Transport Development Services Consultation Response

PROPOSAL: Determination for change of use of office space to two flats with associated parking

LOCATION: 4 Moorfield Chambers, Moorfield Crescent, Yeadon, Leeds, LS19 7EA

PLANNING REF: 23/06618/DPD

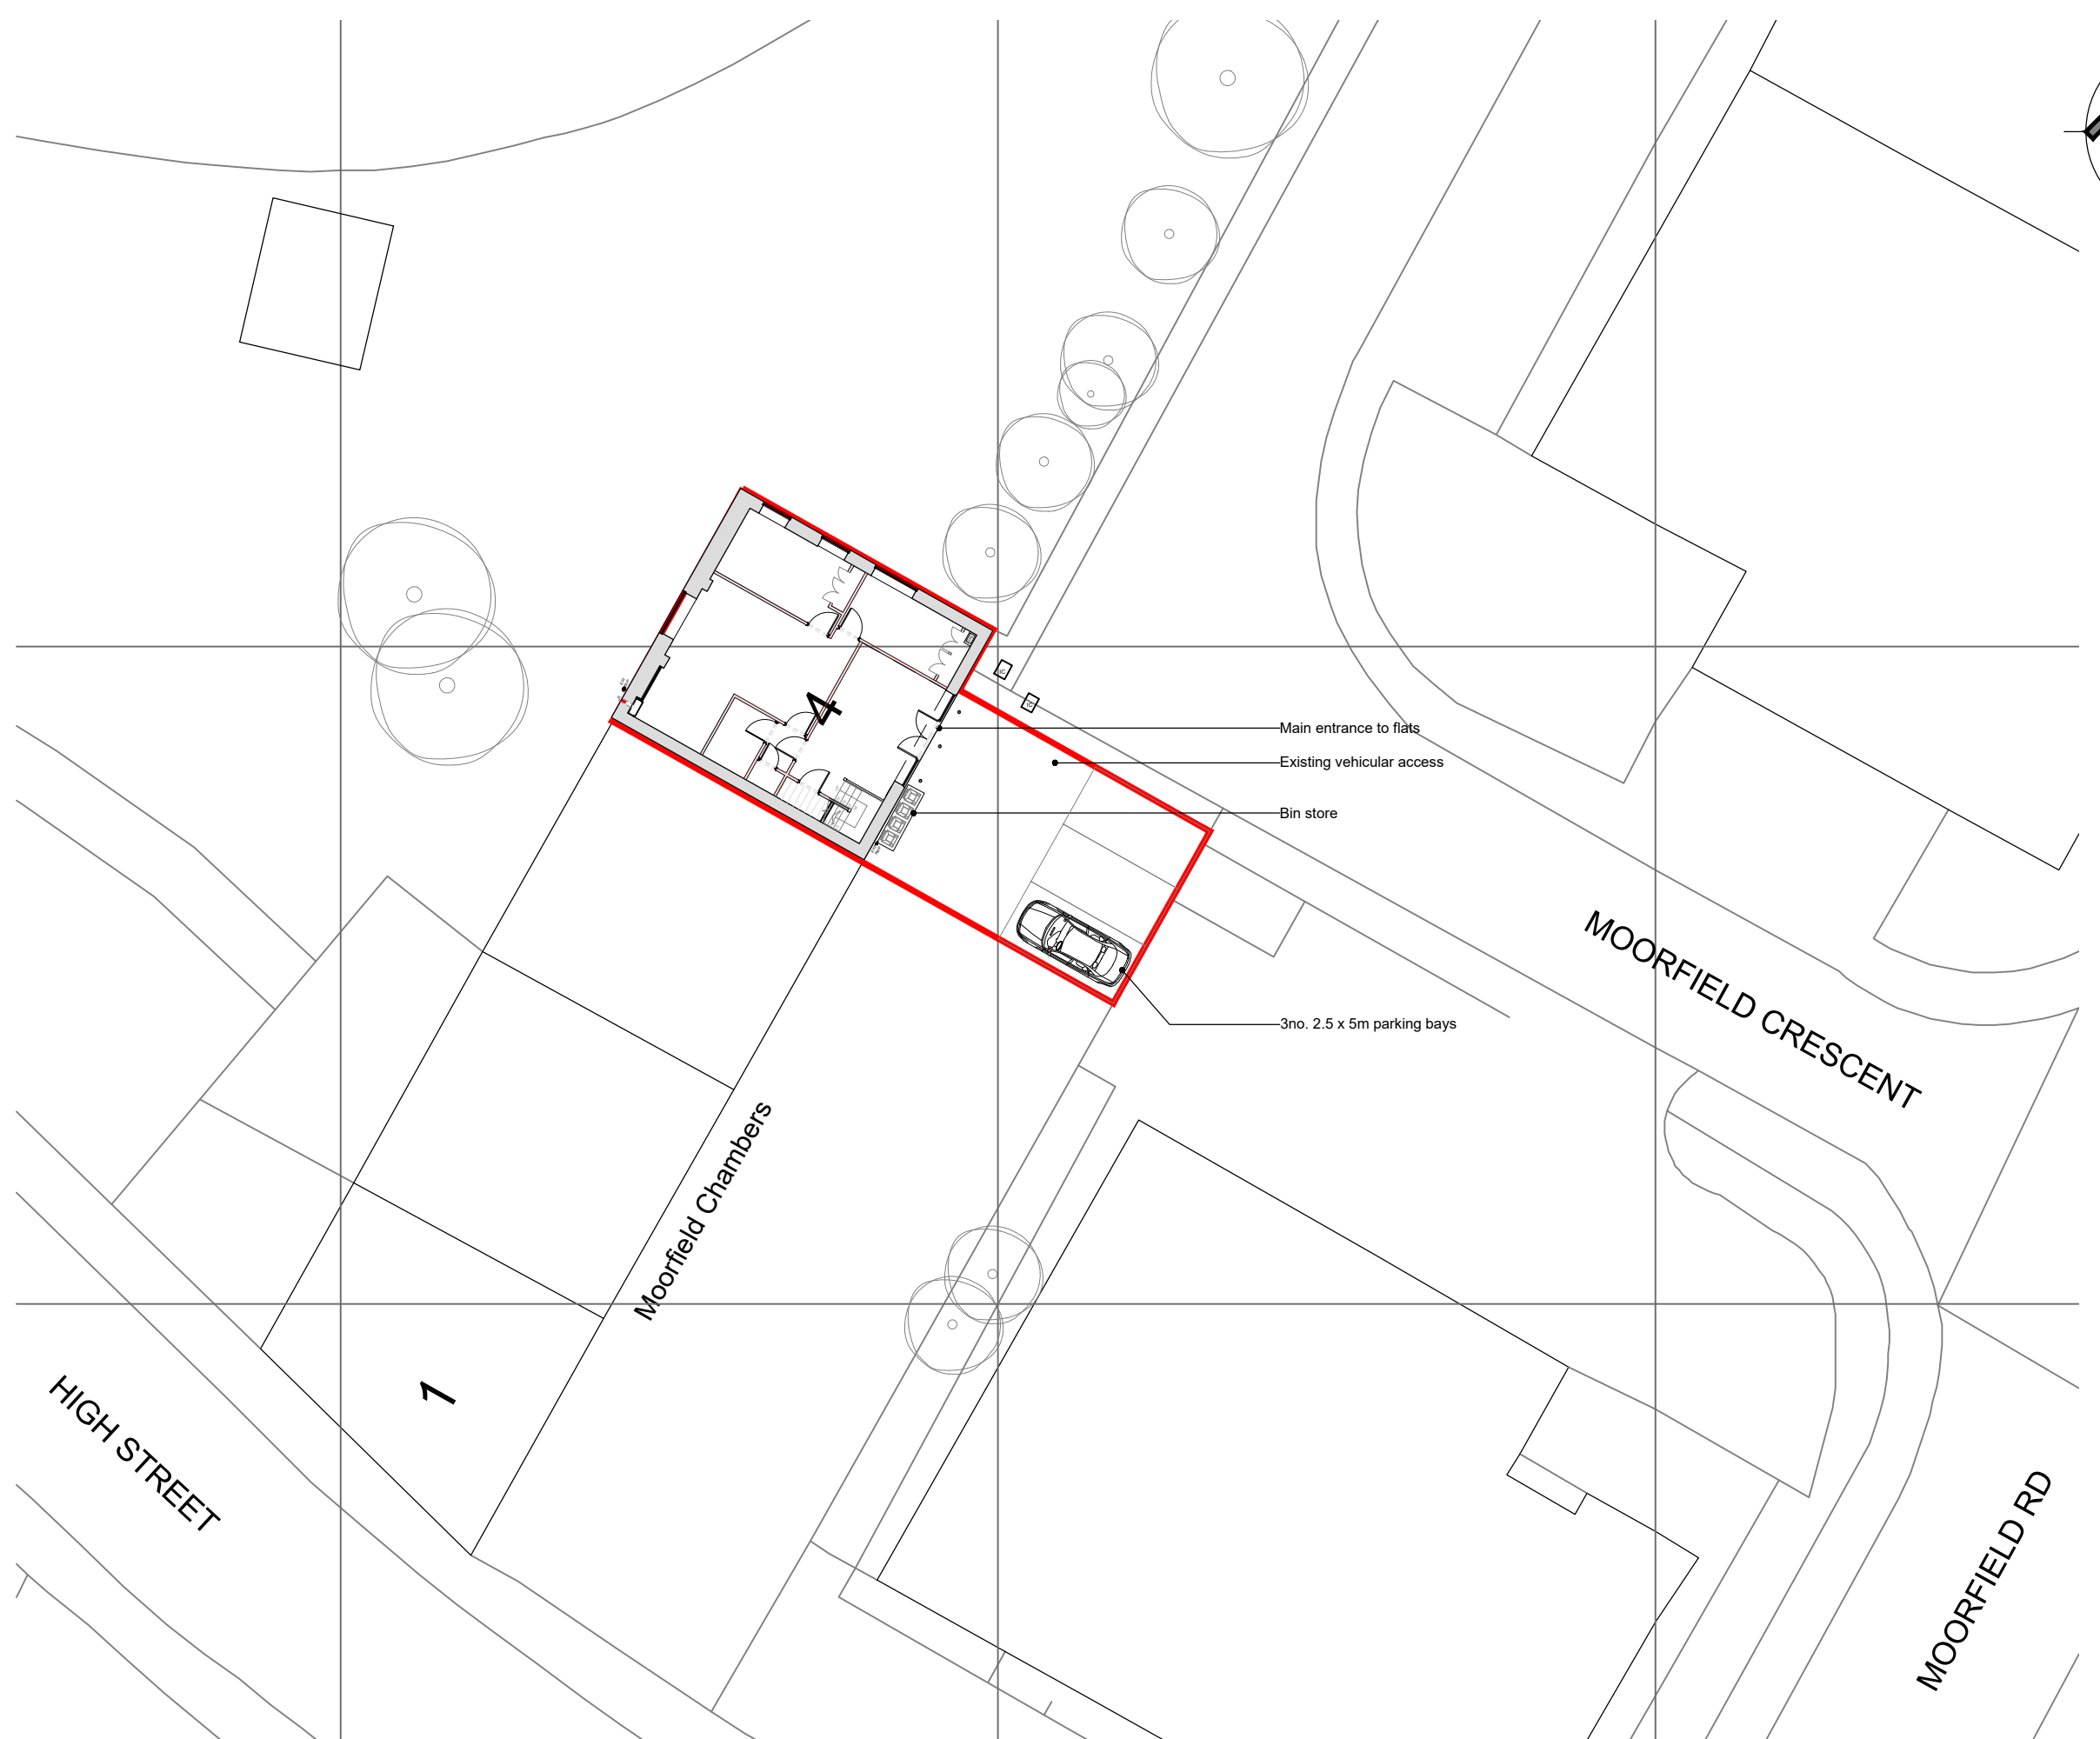
Refuse storage is shown, which is acceptable.

3No 2.5m wide parking spaces are shown, which is acceptable.

One 32 amp smart EVCP is required for each flat.

Cycle parking should be secured, covered and lockable. One space per flat is required. The details will need to be secured by condition.

EXISTING SITE PLAN
1:500 @ A3

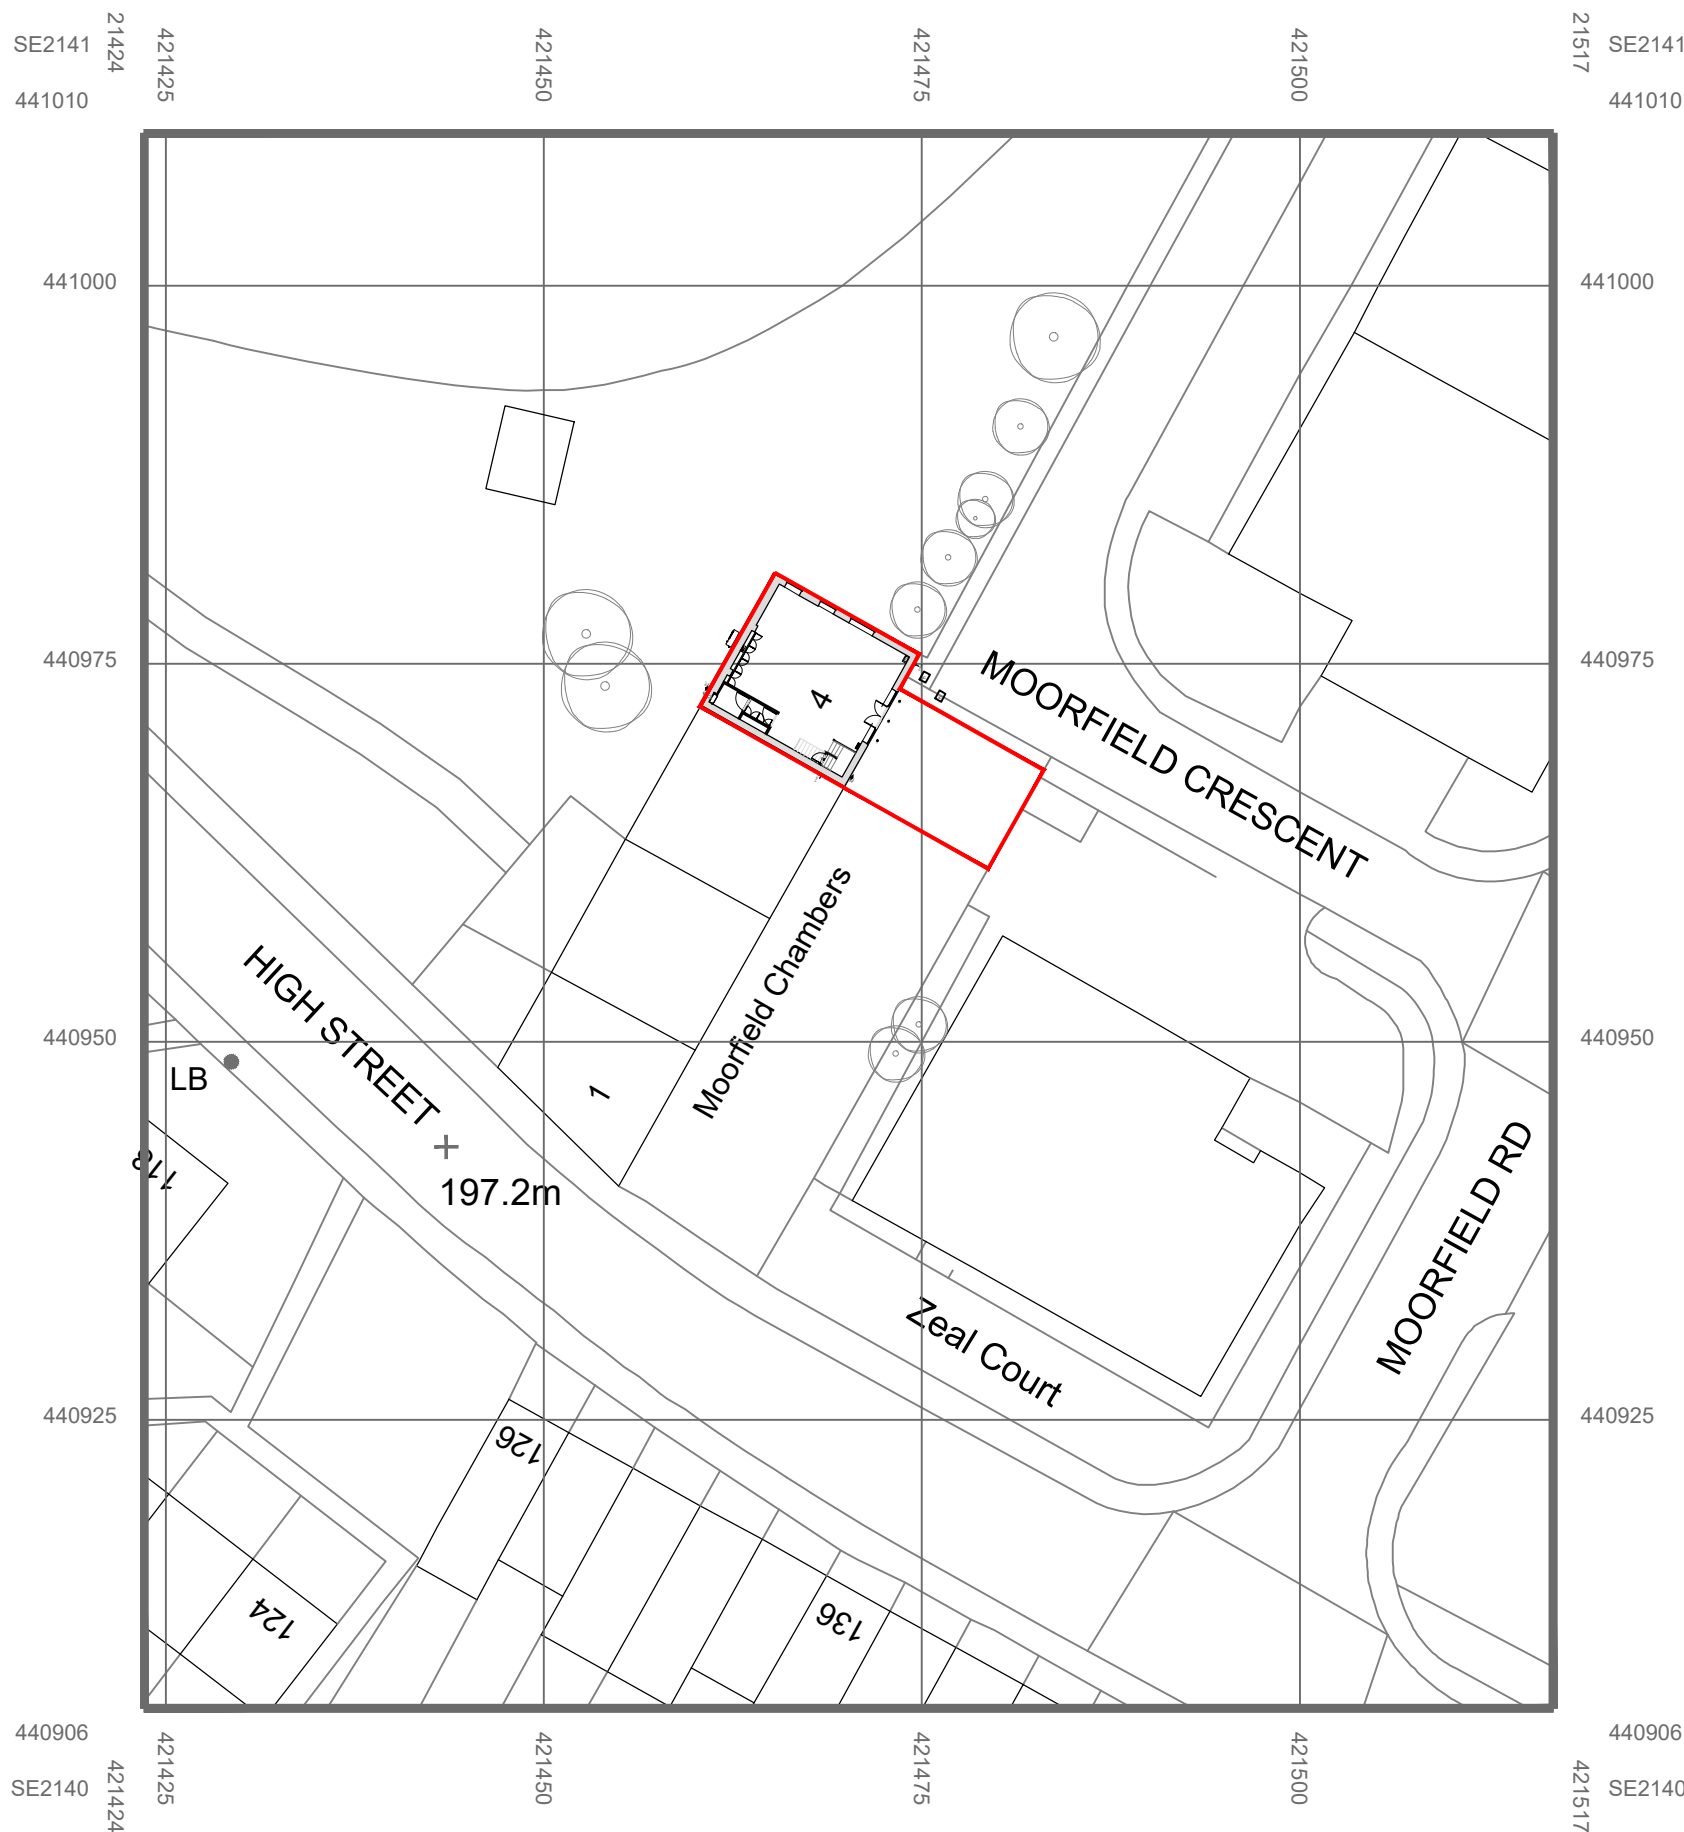
The redline boundary abuts the public highway.
